EPA ADVICE ON ENVIRONMENTAL IMPACT STATEMENT

SNOWY HYDRO - KURRI KURRI POWER STATION (SSI-12590060)

Thank you for your request for advice from Public Authority Consultation (PAE-25649655) on 9 August 2021, requesting the NSW Environment Protection Authority (EPA) review and comment on the Response to Submissions (RtS) in respect of the proposed Hunter Power Project - Kurri Kurri Power Station (Application SSI-12590060) at Hart Road, Loxford (Premises).

The EPA has reviewed the "Hunter Power Project Response to Submissions, Submissions Report" prepared by Jacobs Group (Australia) Pty Limited, dated 4 August 2021 (Submissions Report), including the Revised Air Quality Impact Assessment dated 30 July 2021 (Revised AQIA) and Revised Noise Impact Assessment (Revised NIA).

Figure 6.6: Maximum 24-hour average SO<sub>2</sub> GLC ( $\mu\text{g}/\text{m}^3$ ): natural gas (top) and diesel (bottom)

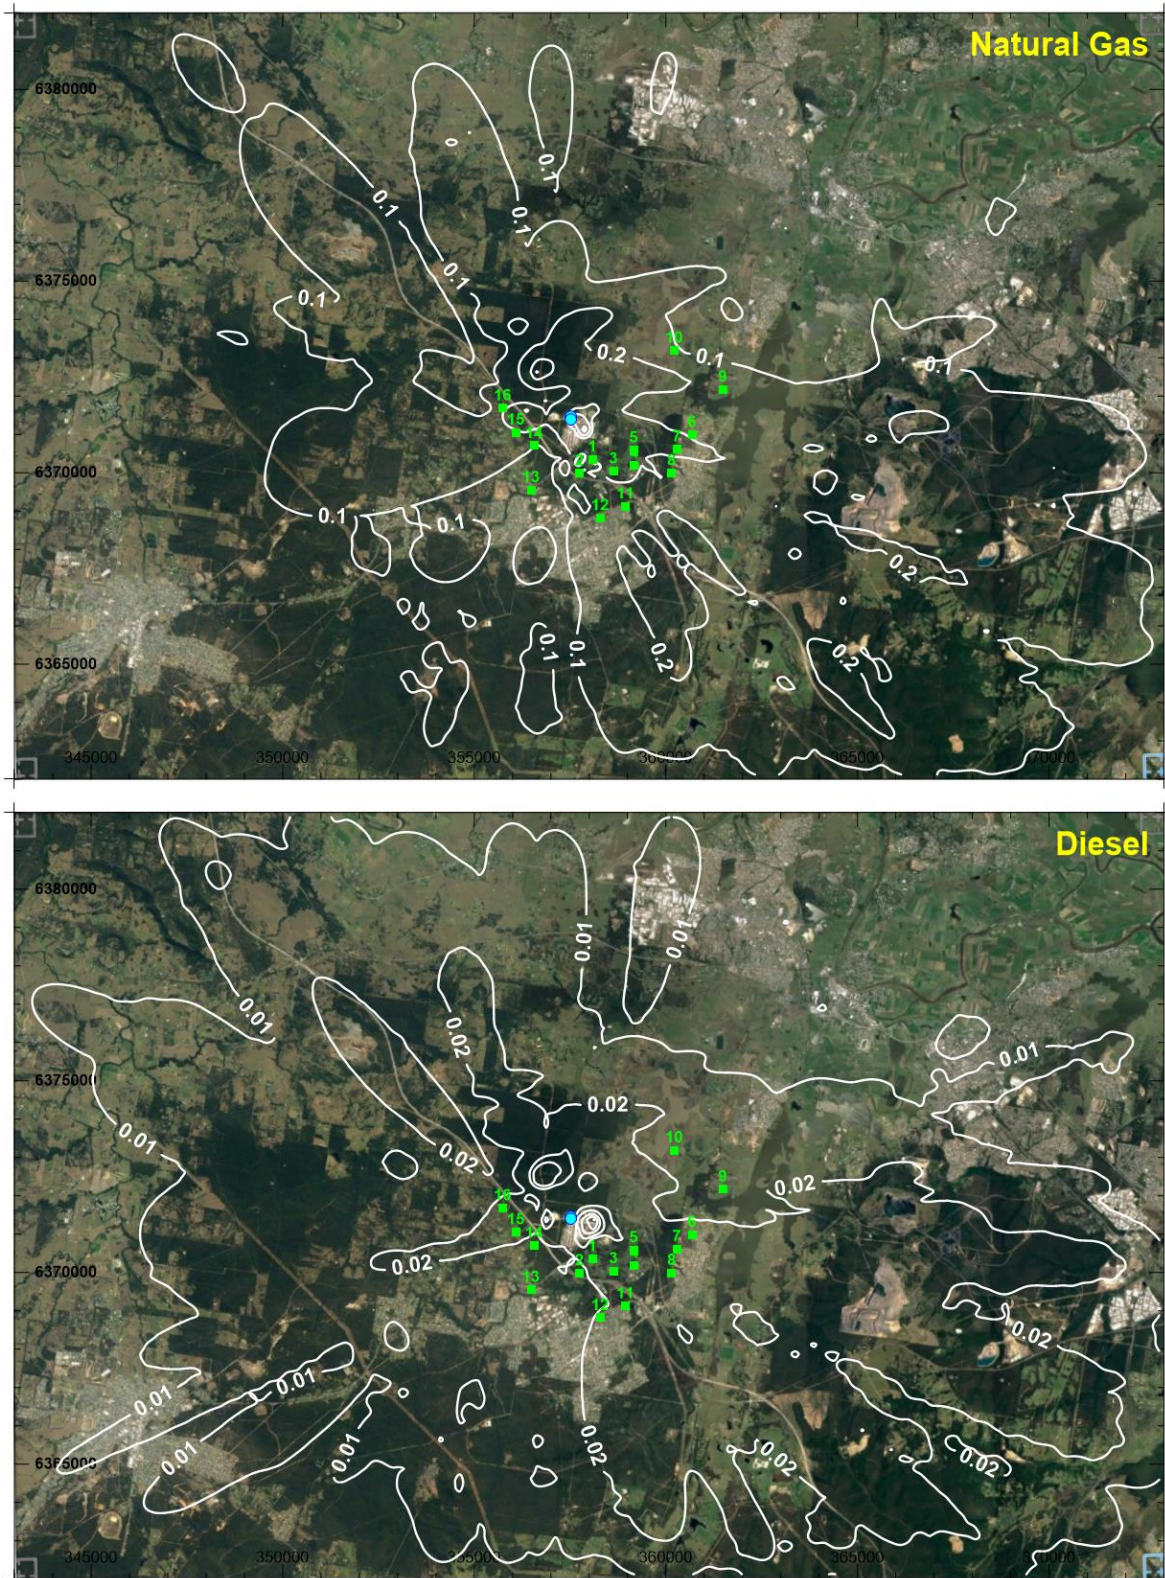
The EPA has identified some specific issues that obfuscate understanding of the results. These include cumulative impact concentrations less than maximum background concentrations (e.g. 24-hour SO₂) and the difference between maximum background and the cumulative impacts presented not corresponding to the incremental impacts in the contour plots (e.g. 1-hour NO_x).

The EPA recommends the proponent provide the results in a clear format that enables understanding of the potential impacts. The proponent should refer to Table 11.3 of the Approved Methods for the Modelling and Assessment of Air Pollutants in NSW and provide a refined assessment for identified receptors which evaluates the cumulative impacts from both the highest backgrounds and the highest increments that includes:

Figure 6.14: 99.9<sup>th</sup> PC 1-hour average CH<sub>2</sub>O GLC ( $\mu\text{g}/\text{m}^3$ ): natural gas (top) and diesel (bottom)

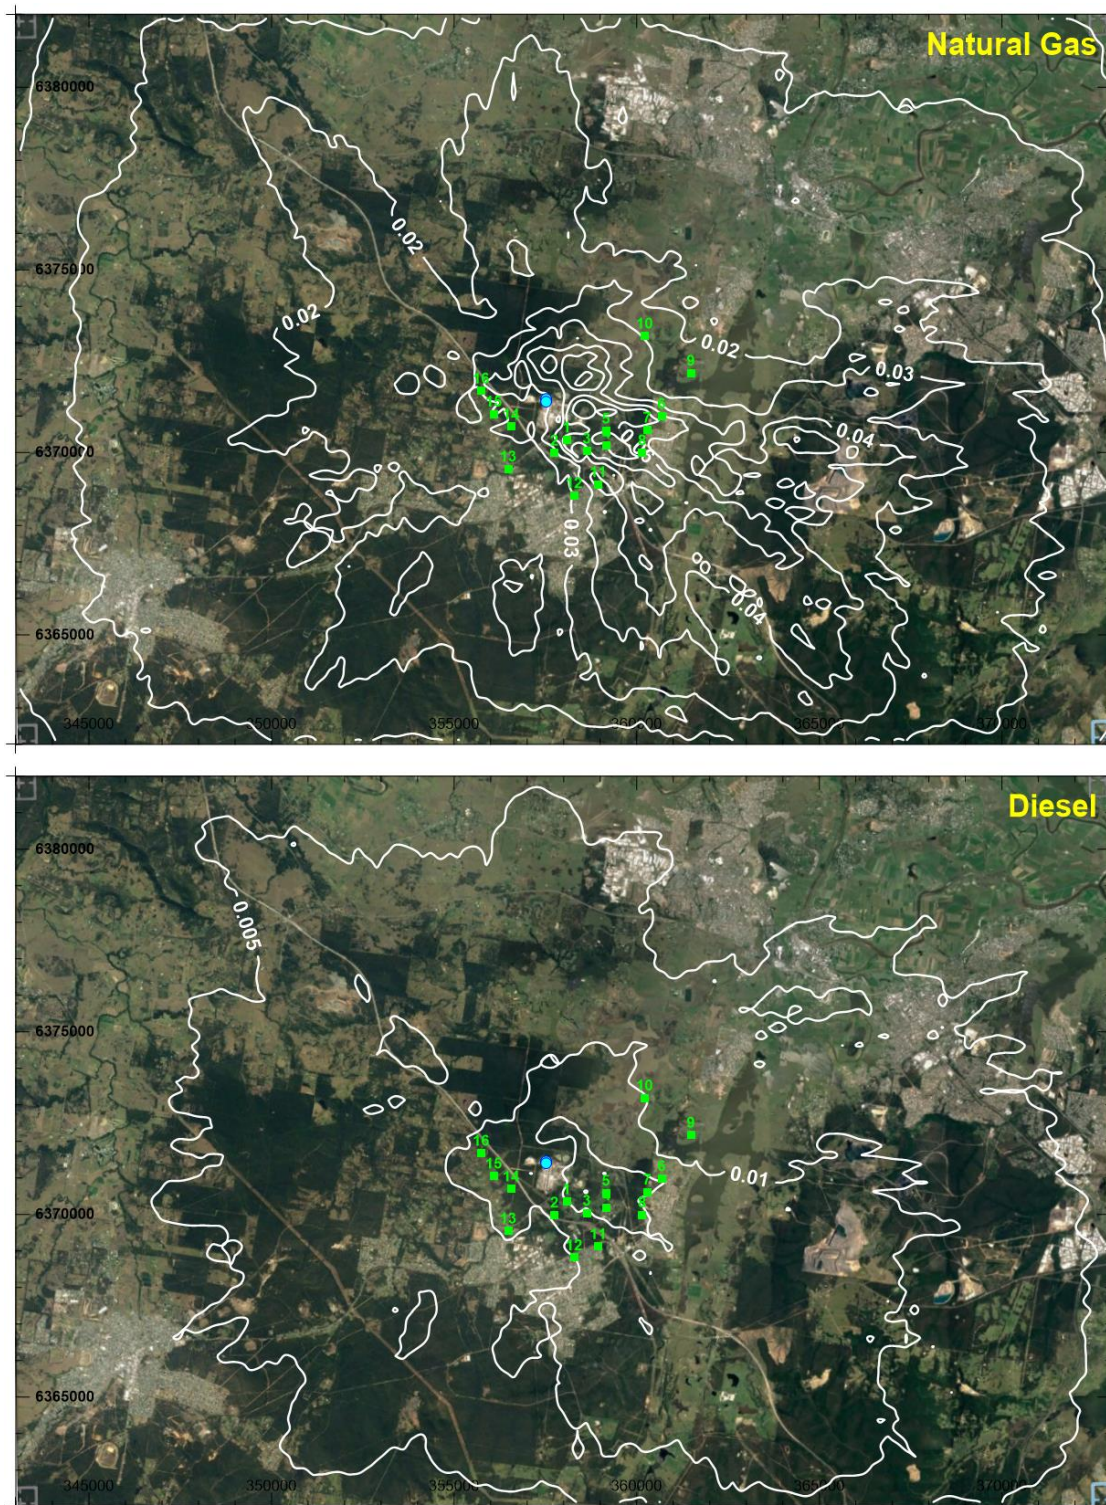
The EPA considers that the Revised AQIA has not provided all the information used to model all the pollutants considered in the assessment. The AQIA has included the toxic air pollutants formaldehyde, acrolein and PAHs as emissions from the proposal (Sections 4.4.7 and 5.2). However, no emission concentrations or rates have been provided nor information on the methodology used to determine the emission rates.

It remains unclear how the predicted impacts of formaldehyde, acrolein and PAHs presented in the results section were modelled and assessed.

The EPA recommends the proponent provide all the information used to model impacts for all pollutants. This includes but is not limited to the methodology used to determine the emission parameters and predicted impacts, including any emission factors and assumptions for pollutants not provided by equipment manufacturers. Specifically, the proponent should provide clarity on the assessment approach of principal toxic air pollutants.
